CITY OF ALBUQUERQUE

March 19, 2019

RE: Wilson Warehouse
6119 Hanover Rd. NW
Grading and Drainage Plan
Engineer's Stamp Date: 02/25/19
Hydrology File: J10D045

C-102

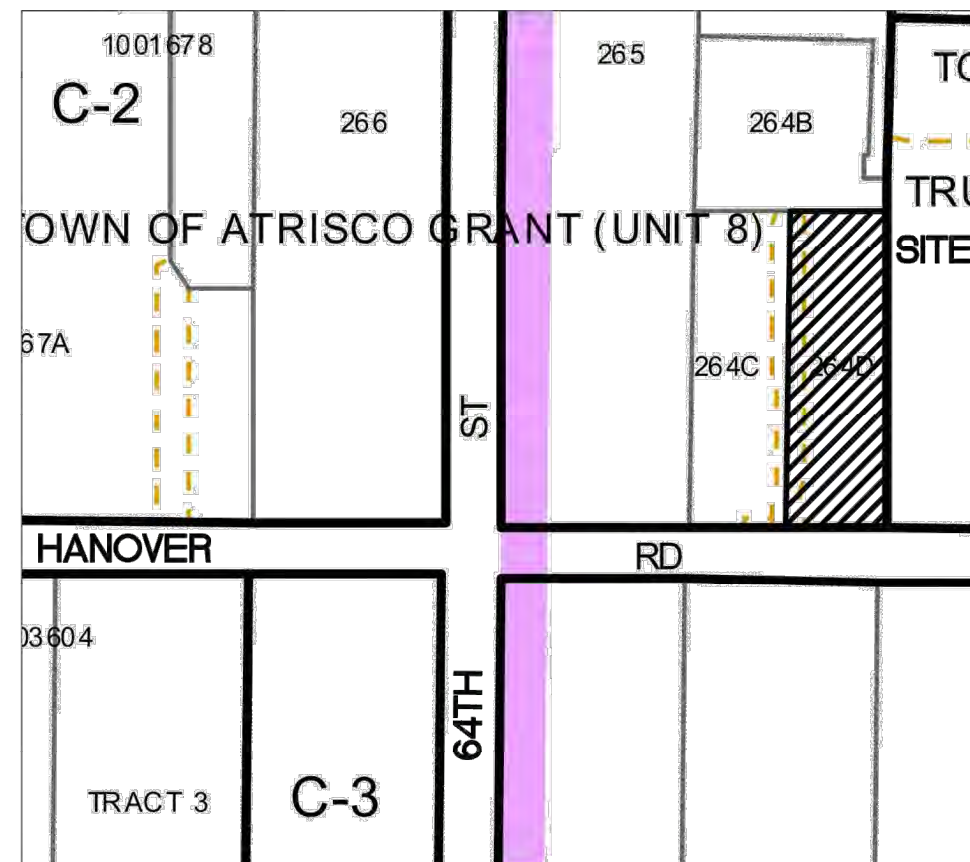
1. Please revise the existing conditions and ultimate conditions per the Tracts 264-B, C, D Unit 6, Atrisco Business Park that was previously approved. See below.

2. Please add a leader and note stating, "Replace/fix section of pond's PVC pipe and place through curb per City of Albuquerque drawing # 2235."
3. Since work within the R.O.W. for the pipe through the curb is needed, please add the SO-19 Permit Notes on the G&D.

4. Please add some kind of note stating, if the existing pond's PVC pipe is damaged during construction, the damaged pipe needs to be replaced.
5. As per the approved permanent Certificate of Occupancy for Tract 264-C dated 6/17/09, the existing pond volume was revised from the required 17,420 cf to 13,074 cf with Tract 264-D conditions as a gravel parking lot. This development is responsible for enlarging the detention pond for the proposed developed conditions. Please provide calculations showing the required volume. If the existing pond volume is sufficient, then routing calculation will need to be provided to back this claim.

6. If the detention pond has to be enlarged, an emergency spillway will have to be installed. The current pond did not have one designed. Also there will need a swale along the east side of the property to Hanover Rd. If this needs to be done, then a sidewalk culvert will need to be installed per City of Albuquerque drawing # 2236. Then the discharge PVC pipe from the pond can also discharge into the sidewalk culvert instead of through the curb.
